Your ref: SSD-23512960
File no: MC-21-00005

SSD-23512960 - Request for advice – Upgrades to Glenwood High School at 85 Forman Avenue, Glenwood

Blacktown Council's submission to SSD-23512960 – Upgrades to Glenwood High School at 85 Forman Avenue, Glenwood

status	scale at A1 1:250	drawn by NKK	checked KEH	rev. I
project no. 6393	drawing no. CV-0201

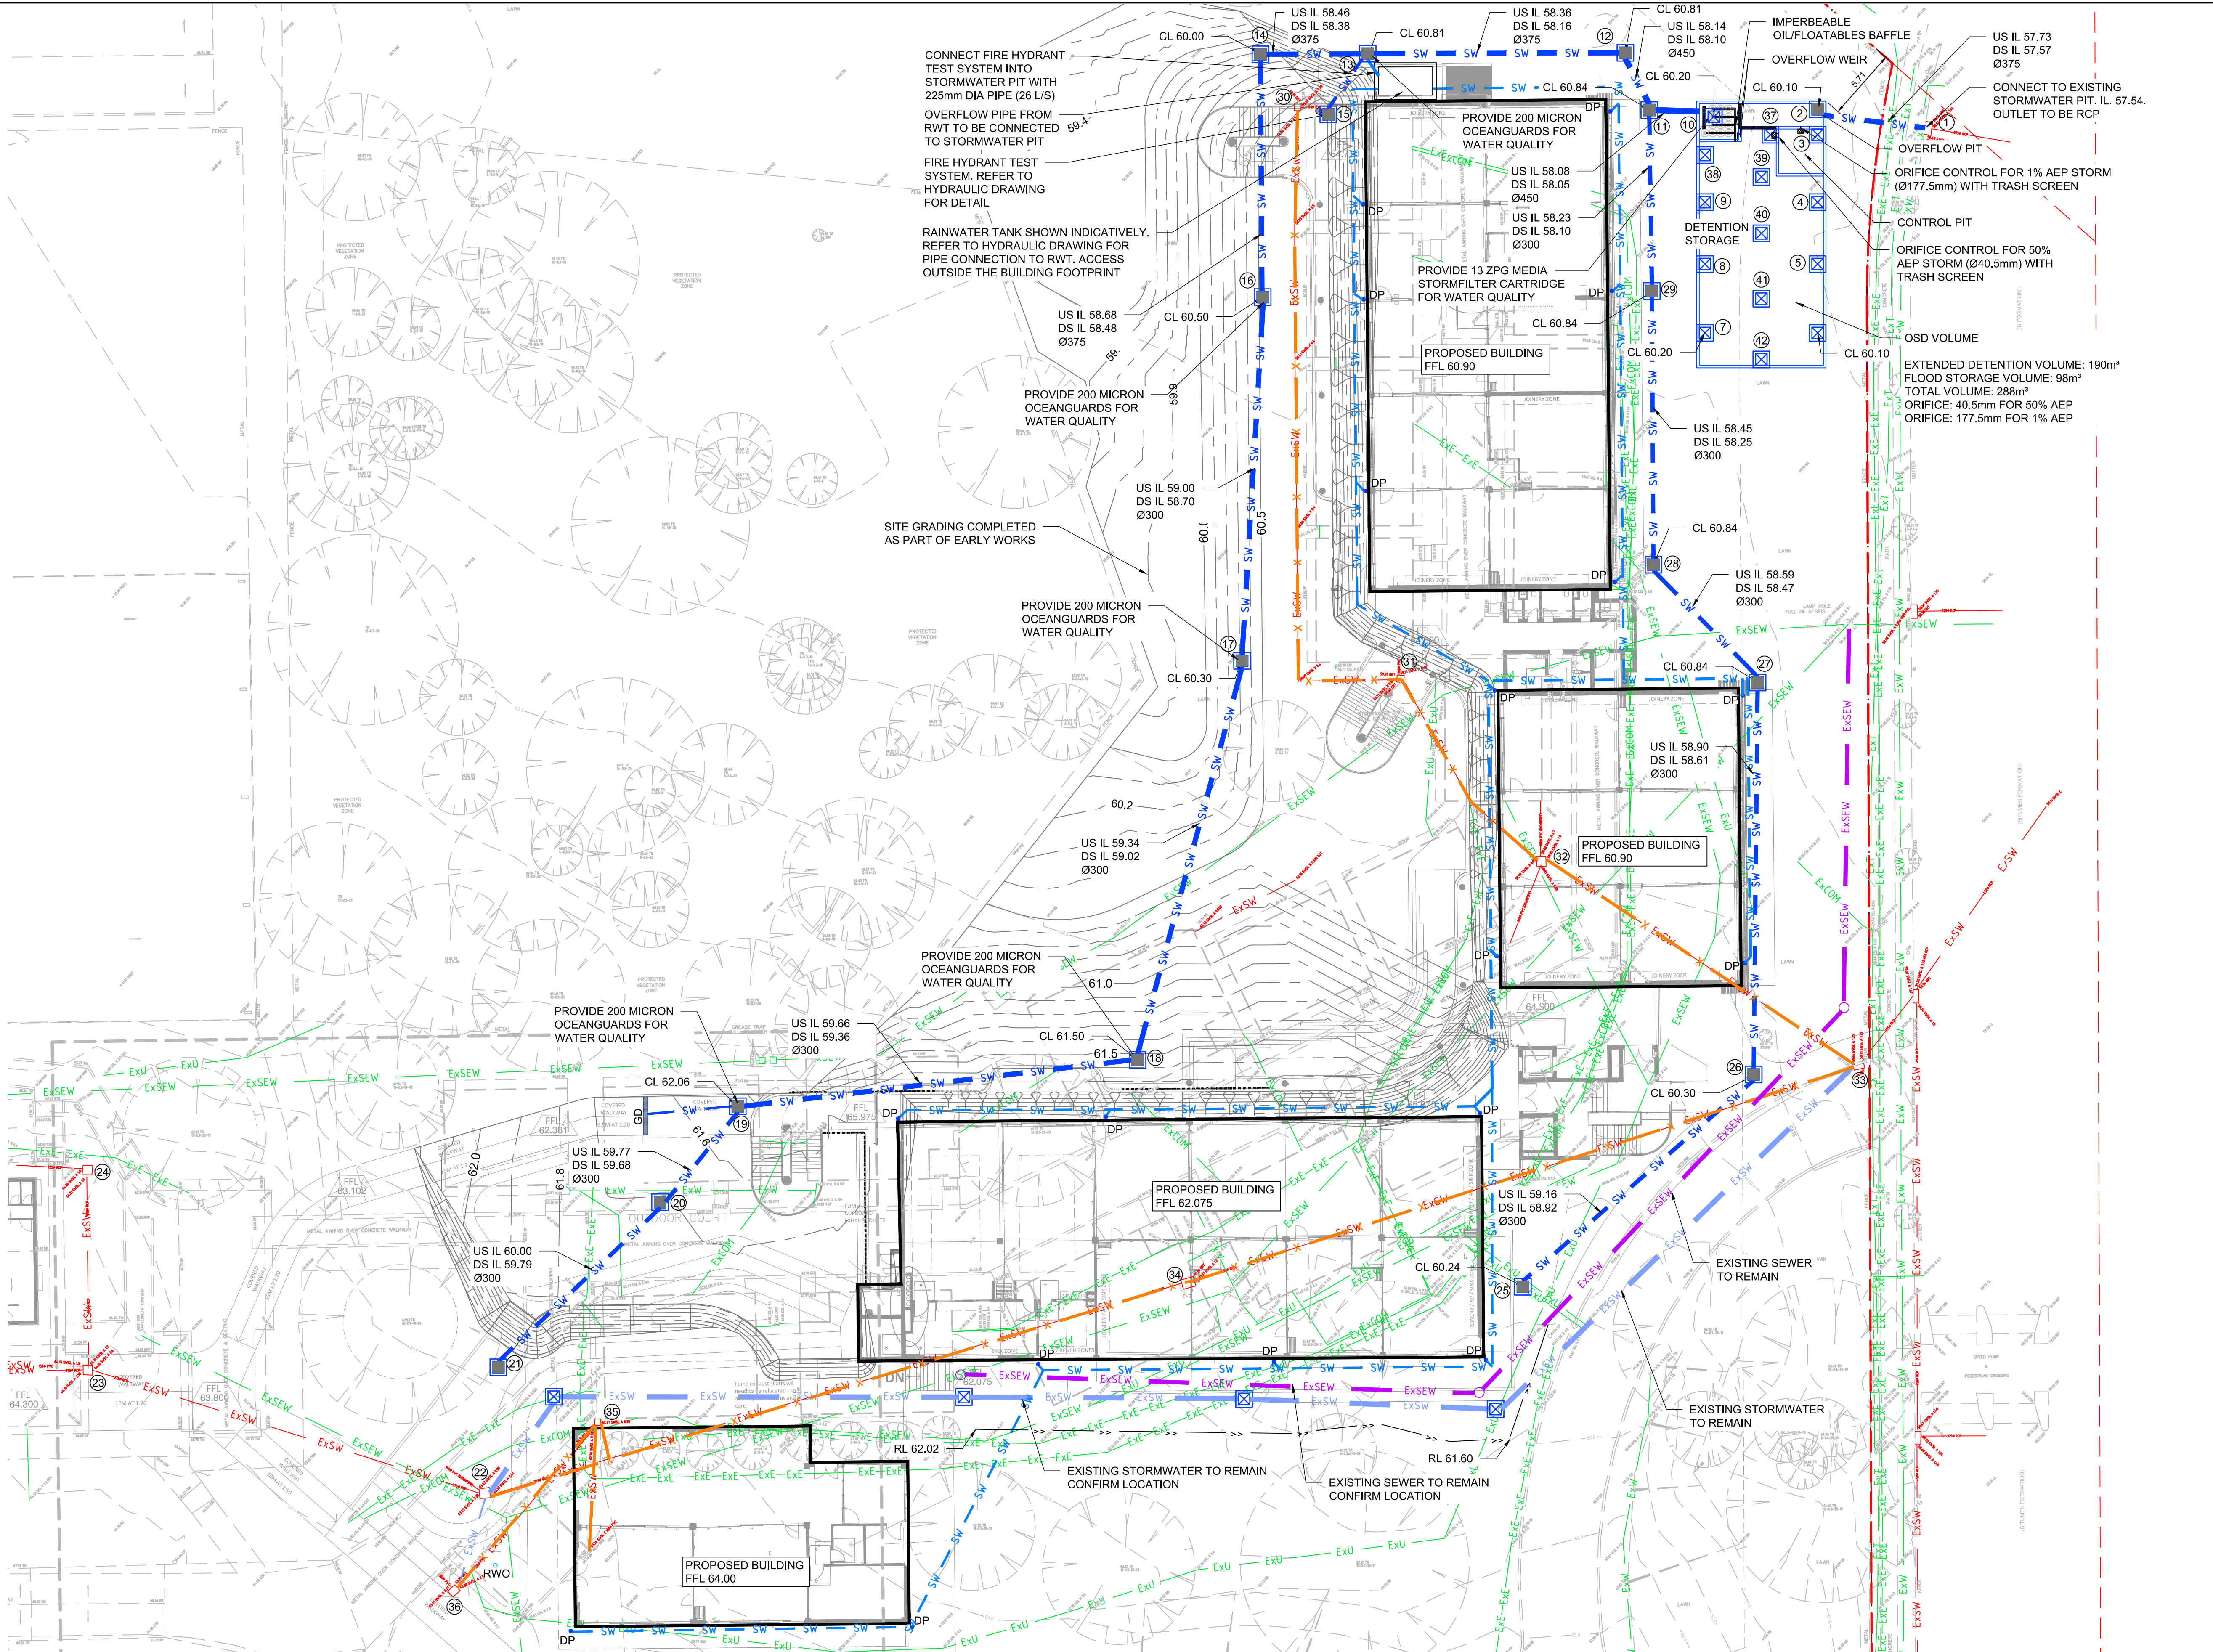
- On drawing 0201 (A):
 - i. Show how the roof water gets to the rainwater tank. Provide a separate system for roof water and surface drainage. Pits between the roof lines (i.e. charged pipes) are to be sealed.

- ii. Provide details of the rainwater tank including pre-treatment, volumes, sections, dimensions etc.
 - iii. The 375 mm diameter outlet to the existing stormwater Pit 1 is to be RCP.

- iv. Provide levels of the existing street Pit 1 and confirm the connection level to this pit.
 - v. It is unclear whether Pits 18 and 27 are treating surface flows and all or only part of the upstream pipe flows as well. Provide detail for Pit 18 and 27 showing all invert levels for all pipes.

- vi. OceanGuards should treat a maximum of 1000 m² of non-roof areas and 1500m² of roof areas. All OceanGuards are to be clearly notated as "200 micron OceanGuards".

- vii. OceanGuards treating only surface flows require a minimum clear depth of 500 mm below the grate to any inlet or outlet pipe obvert. OceanGuards treating surface flows and upstream pipe flows require a minimum clear depth of 500 mm from the invert of the upstream pipes to be treated, to the obvert of the outlet pipe. Where these pits are treating upstream pipe flows the inverts of all pipes in and out of the pit are to be shown.

- viii. Where OceanGuards (Enviropods) are designed to treat upstream pipe flows, the invert levels on all pipes discharging to and from the pit are to be clearly shown. Provide a minimum clear depth of 500 mm from the invert of the upstream pipes to be treated to the outlet pipe obvert.

- ix. Provide a pit detail with an Oceanguard fitted.
 - x. Review the pit size as 600 * 600 mm pits are limited to 600 mm maximum depth and 600 * 900 mm pits are limited to 900 mm depth. Pits greater than 900 mm depth are all to be minimum 900 * 900 mm. All pits within the proposed development must comply with these requirements.

- xi. Charge line cleanout pits are to be provided at the low point of all charge line systems for the rainwater tanks to facilitate cleaning of the system.
